CITY OF ALBUQUERQUE

September 29, 2022

RE: BOB'S BURGERS III
305 Eubank Blvd. NE LVD NE, Albuquerque, NM 87123
Grading and Drainage Plan (K20D049)
Engineers Stamp Date 9/2/2022

SHEET TITLE
GRADING &
DRAINAGE PLAN

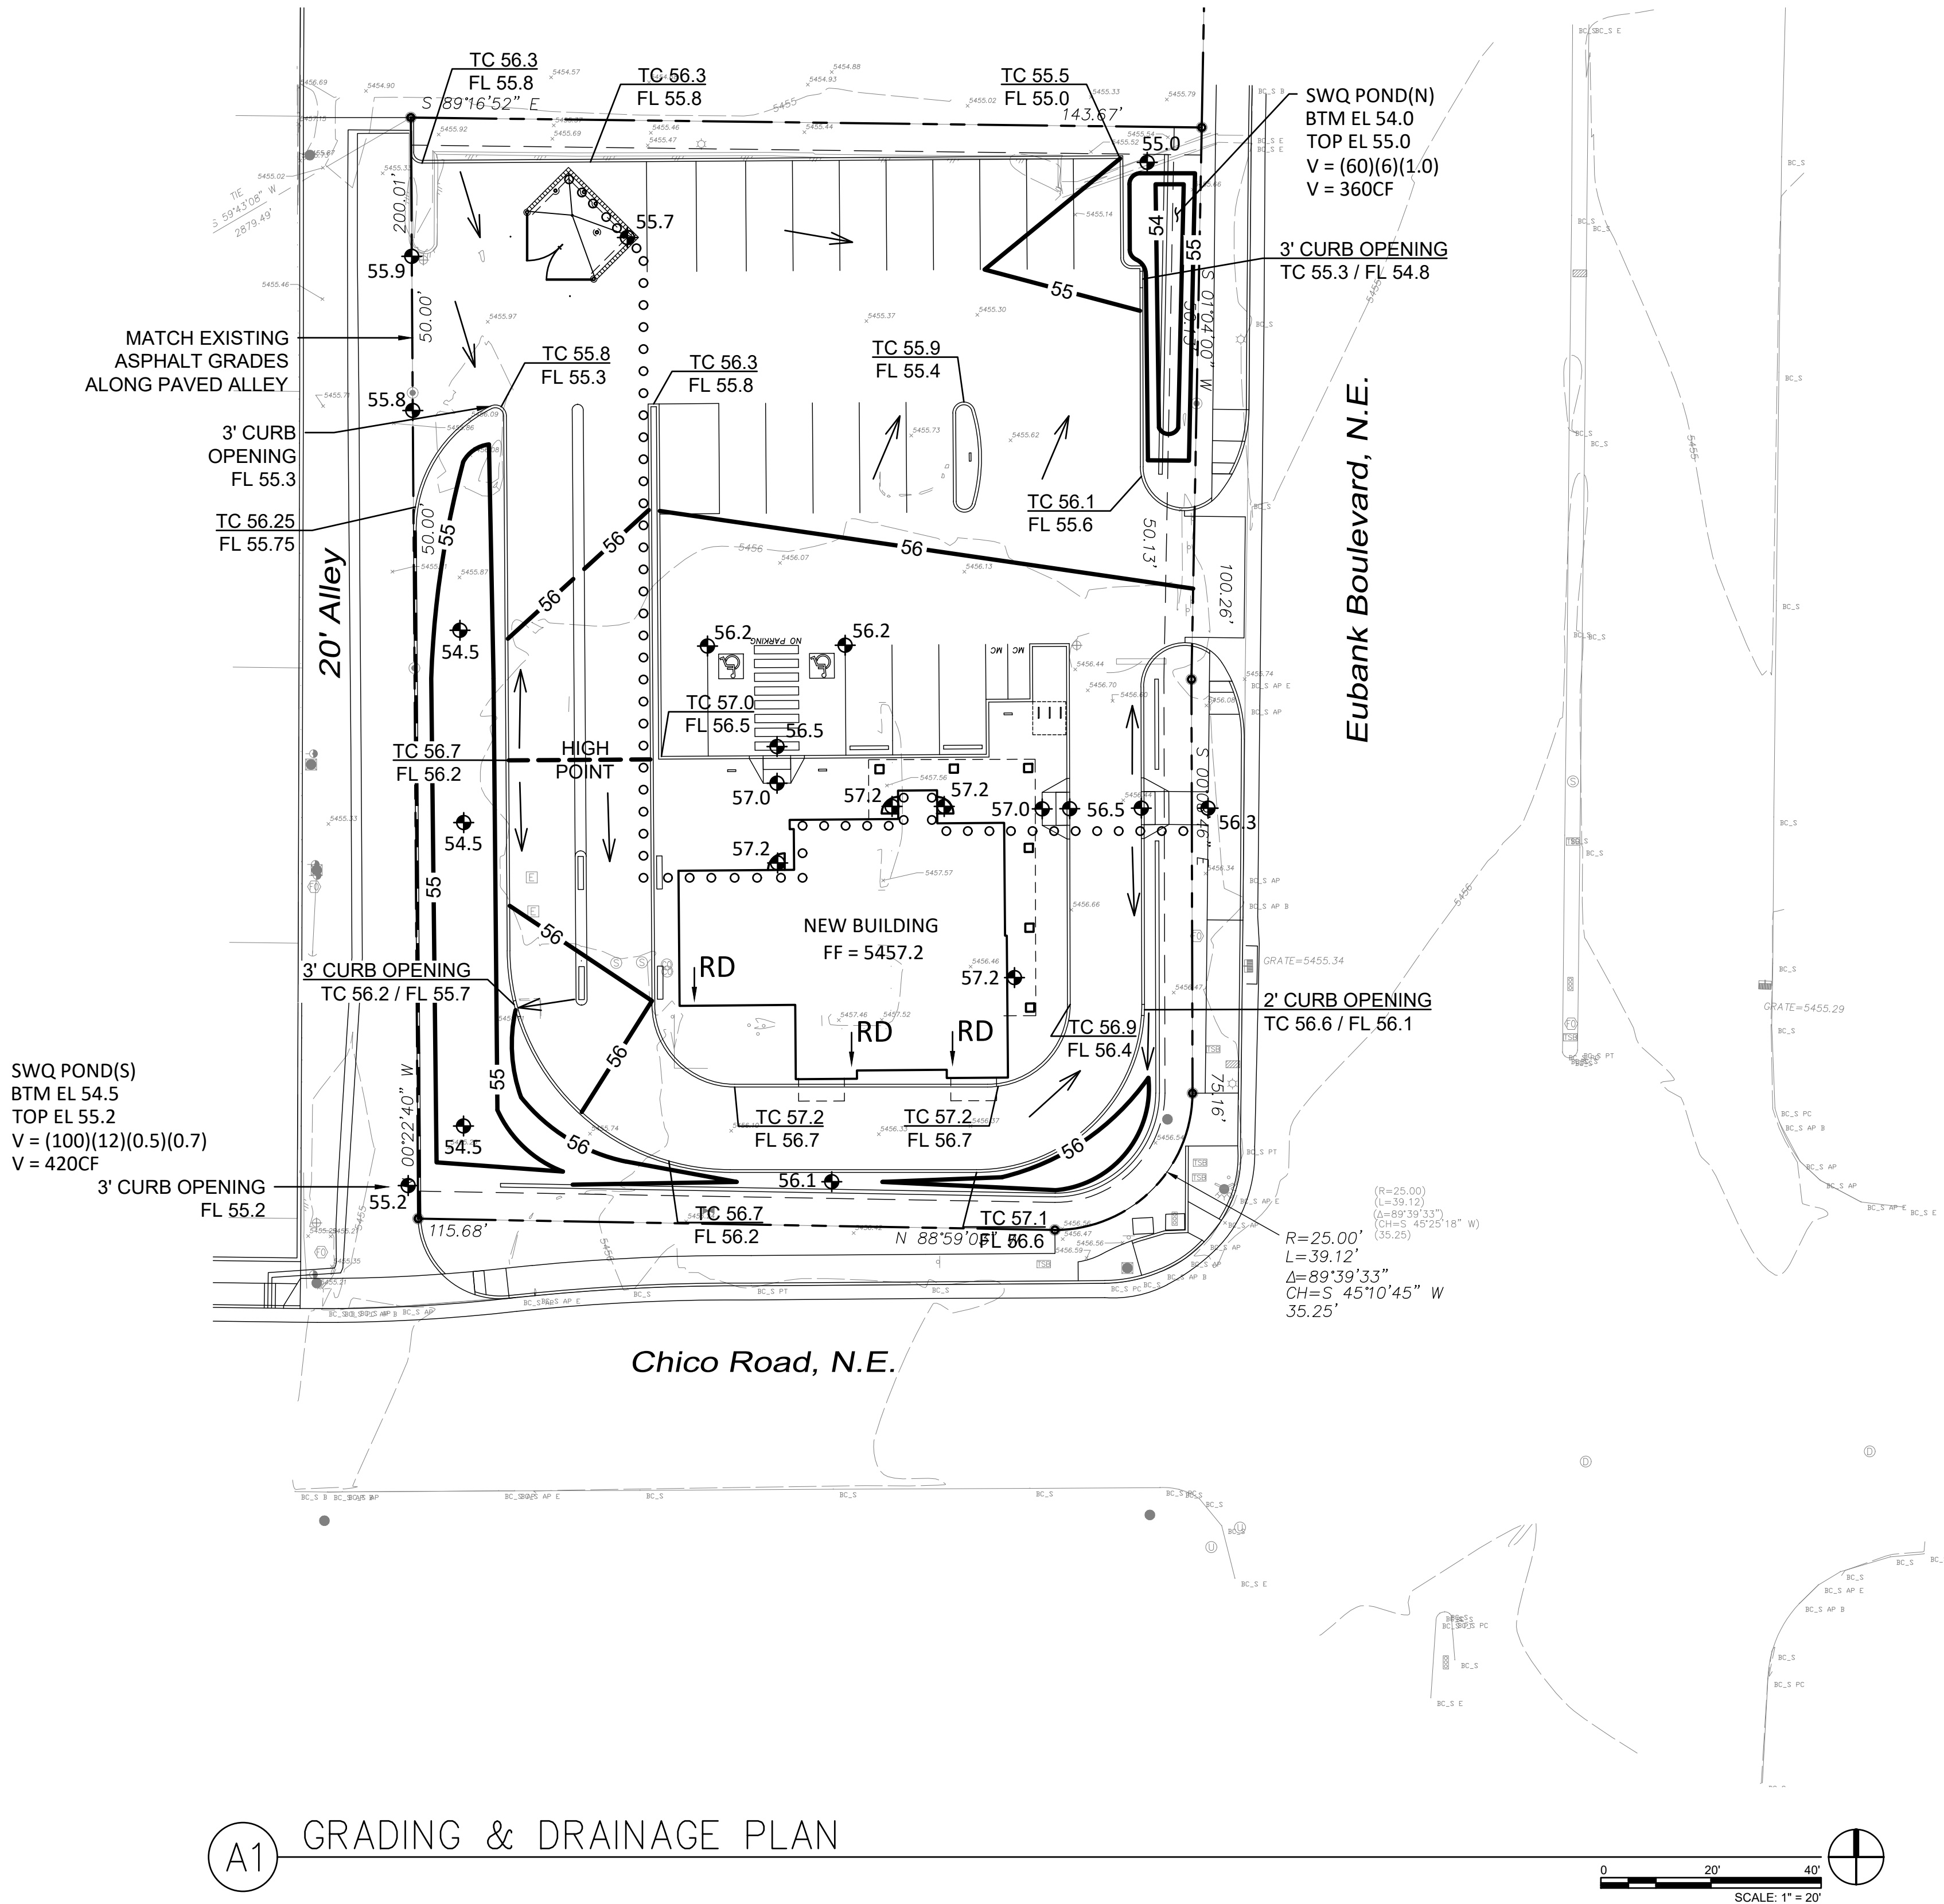
- 1) Please clearly show existing spot elevations and contours
- 2) Ensure that 1' water block is provided at the entrance from Eubank Blvd. Provide detail grades to meet ADA requirements.

- 3) Overflow from the proposed ponds cannot be over the public sidewalk. The pond along the alley can be directed to overflow onto the alley. A sidewalk culvert would be needed for the overflow from the pond along Eubank Blvd. Is the existing sidewalk culvert at the NE corner of the lot going to be used for this purpose? Provide calculations to ensure it is sized for the amount of the runoff. Part of small concrete channel must be removed. Provide SO-19 Notes if a new sidewalk culvert is going to be constructed with this plan.

- 4) The runoff from the trash enclosure must drain to a floor drain within the trash enclosure and then to a grease trap (possibly the proposed grease trap for the restaurant). From there the runoff must drain to the sanitary sewer line.

- 5) Is the pavement in the alley in good condition?
- 6) Provide spot elevations at all proposed ramps within the right-of-way to ensure ADA requirements are met.

- 7) Is the existing entrance being relocated on Eubank Blvd.?
